Application No: AB/101/21/HH
Site Address: 43 Torton Hill Road Arundel BN18 9HF
Description of works: Erection of two storey side/rear extension, porch to front with associated alterations to fenestration and drainage works.

Thank you for your internet representation made on 28th September 2021 which has been recorded as an objection with the comments as follows:

AB/101/21/HH - 43 Torton Hill Road Arundel

Elevations as proposed

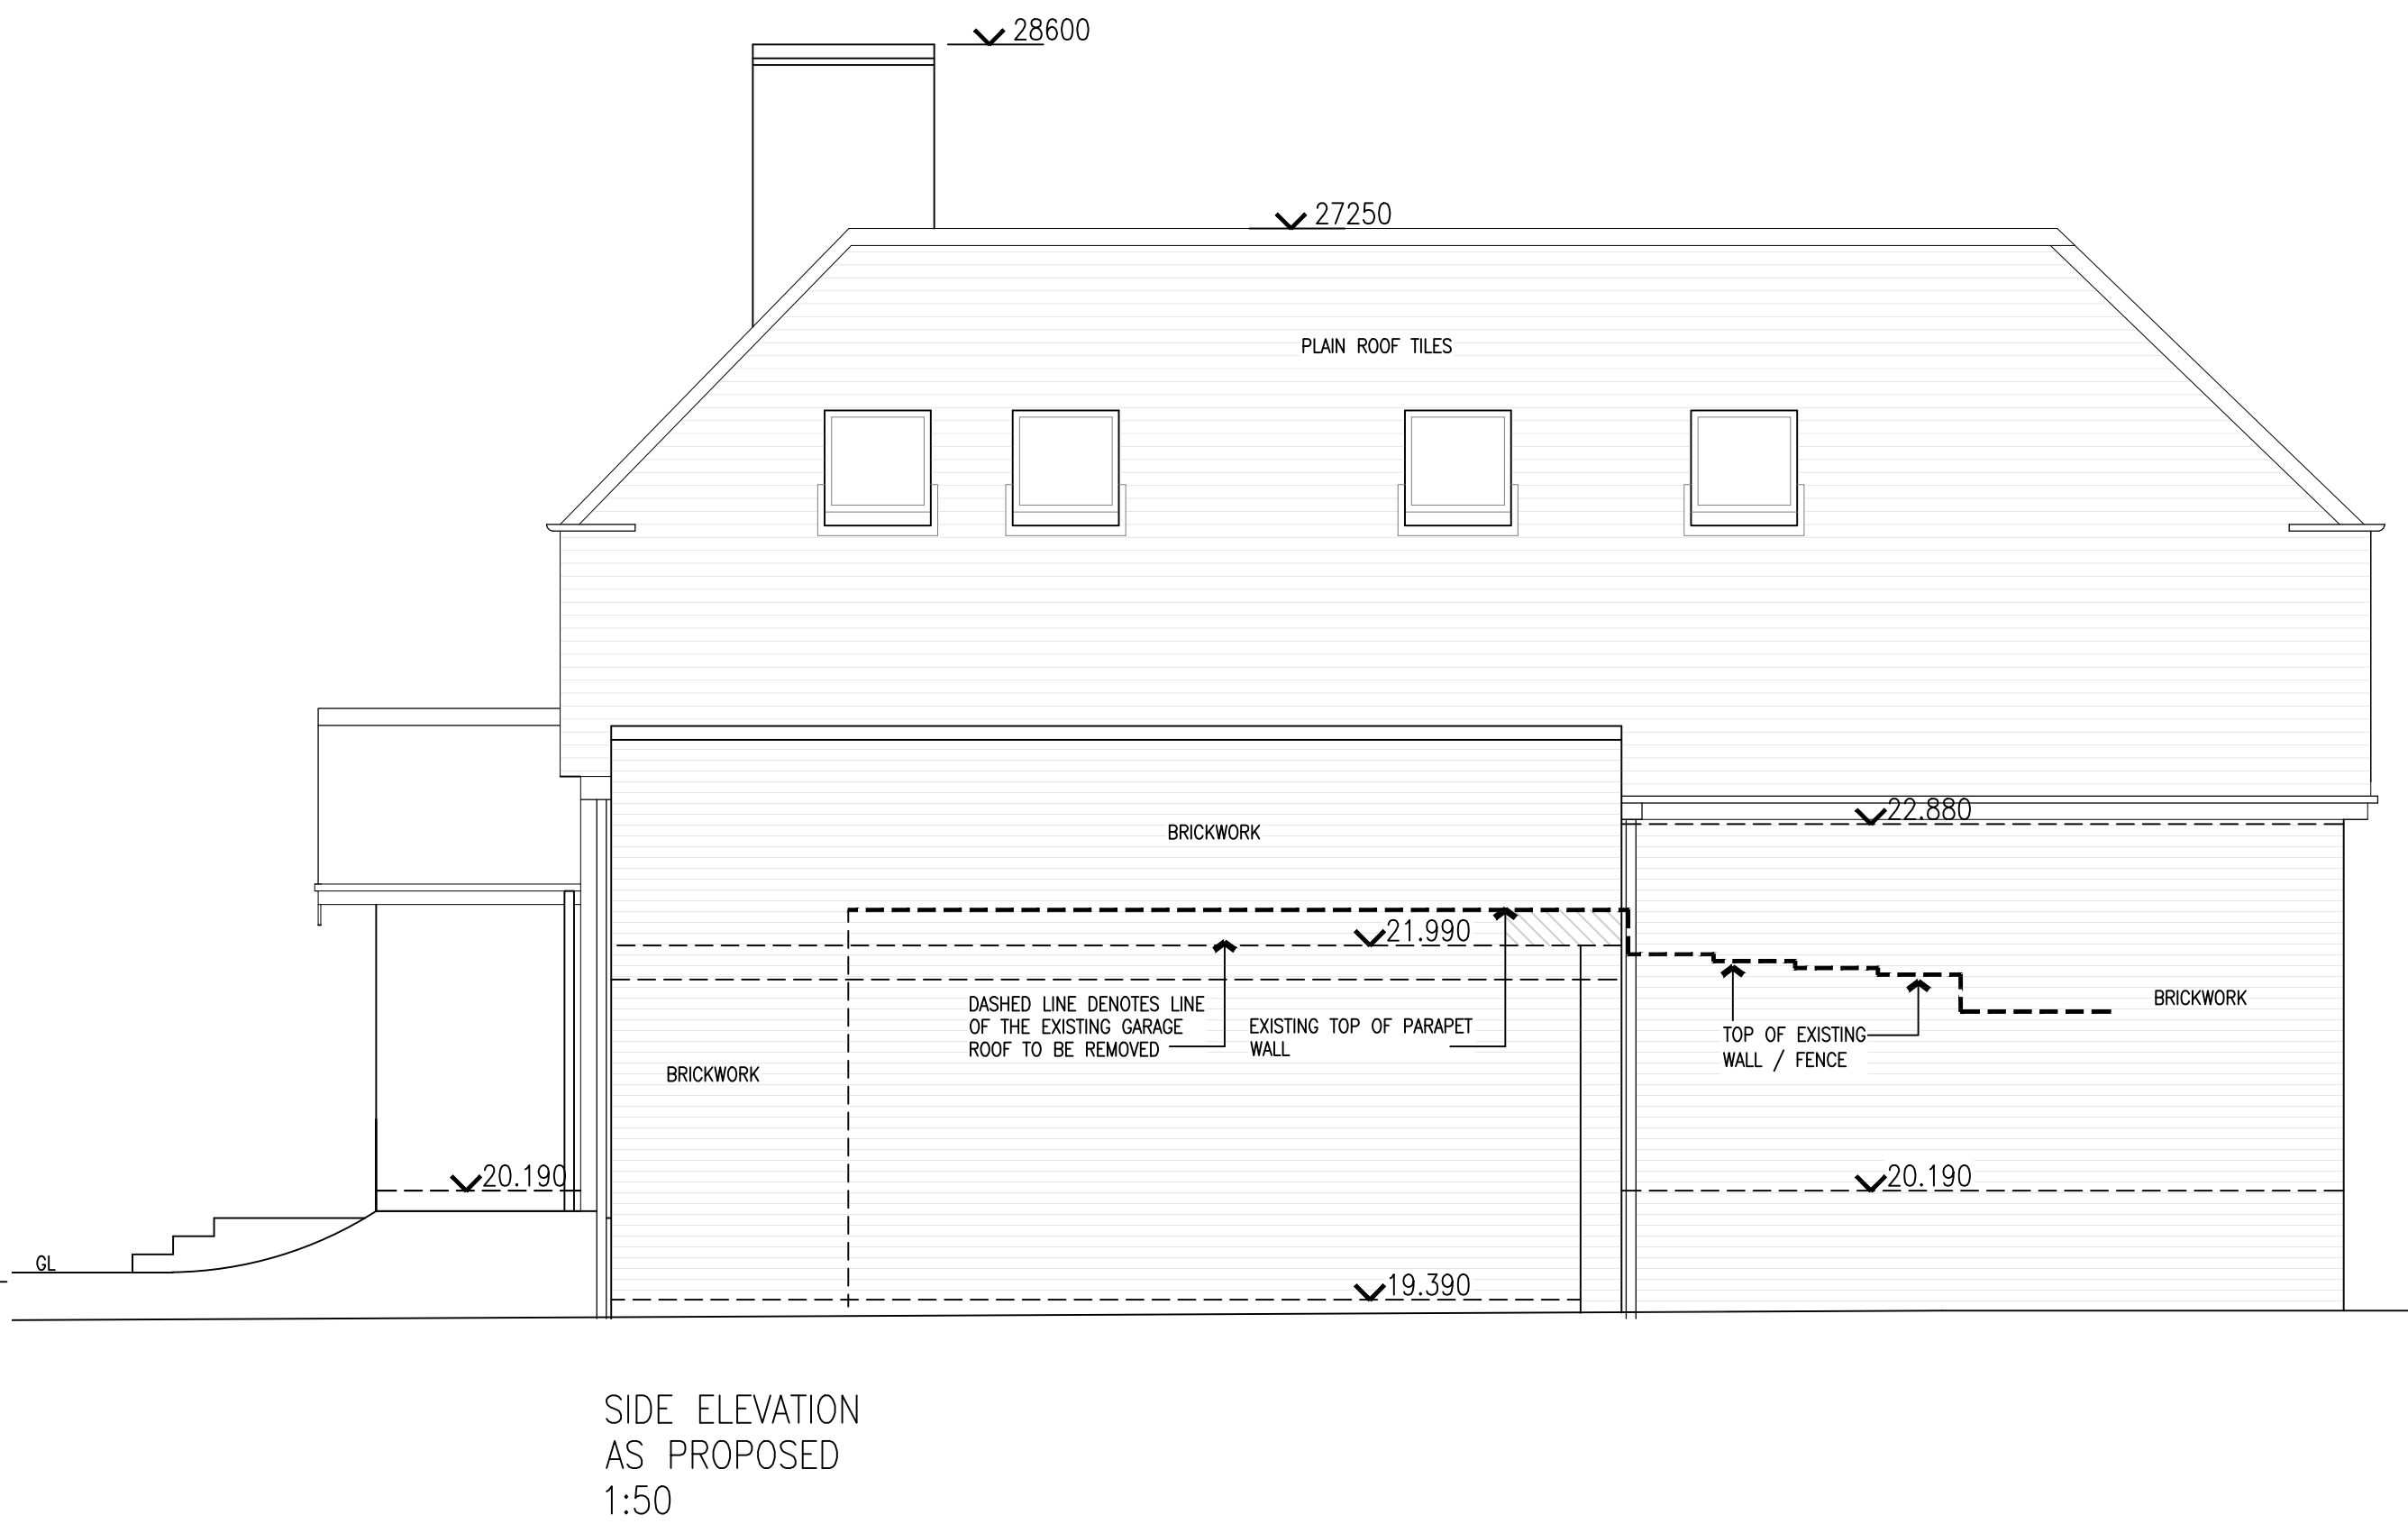
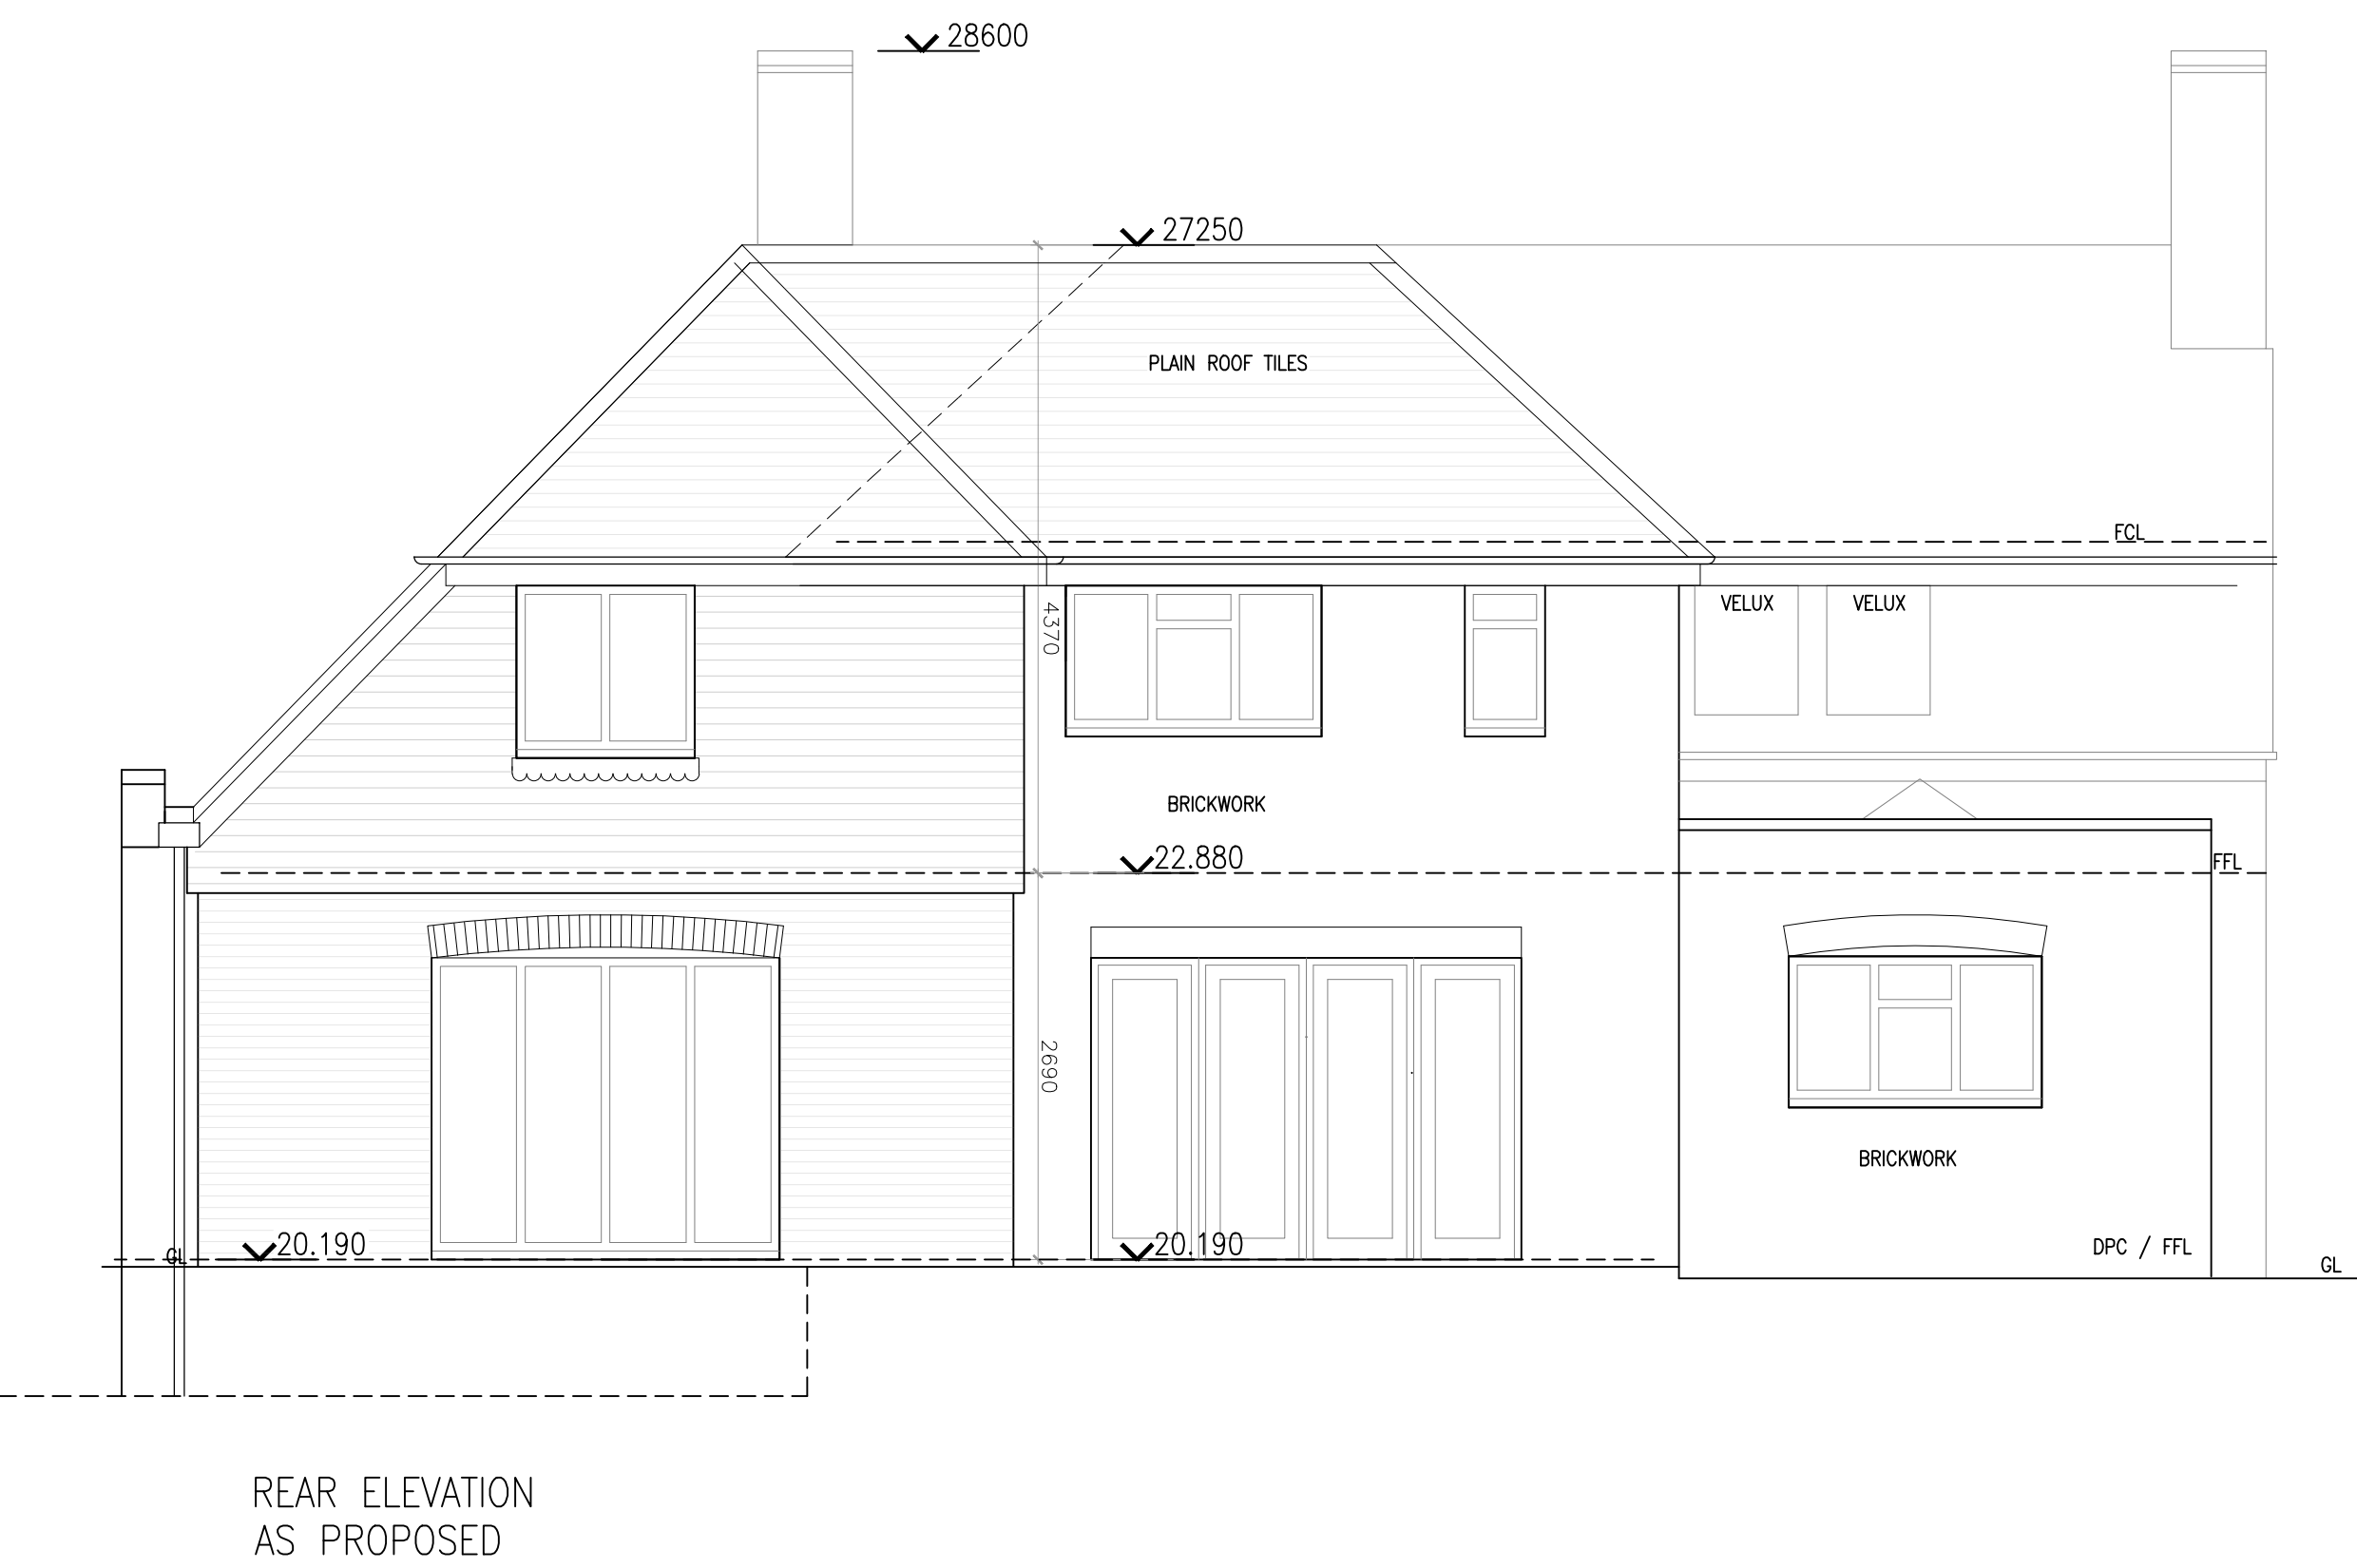
- Side Extension - Objection to the addition of Velux windows along the side extension as this will impact on the privacy of 45 Torton Hill Road. There are two Velux windows at 45 Torton Hill facing directly opposite the party wall for the proposed extension. Due to the proximity between the two houses this will compromise the privacy because four Velux windows on the proposed side elevation are of a size, height and angle that will allow direct visibility into the existing Velux windows (lavatory and family bathroom) of 45 Torton Hill, compromising privacy. In addition, windows will allow direct observation into both side and rear patio gardens removing the only private space in the garden for number 45.

- Side Extension - The intended works clearly encroach on the existing party wall shared by 43 Torton Hill and 45 Torton Hill. For the record, of concern to the owner of number 45 it seems that the party wall will be heightened and modified, terminating in a parapet at the gable. Therefore, as the owner of number 45 I would require provision to drain rainwater runoff without any encroachment on / or over the parapet for number 45. Runoff to be contained/ drained to existing points under Part G (2015) Building Regs.
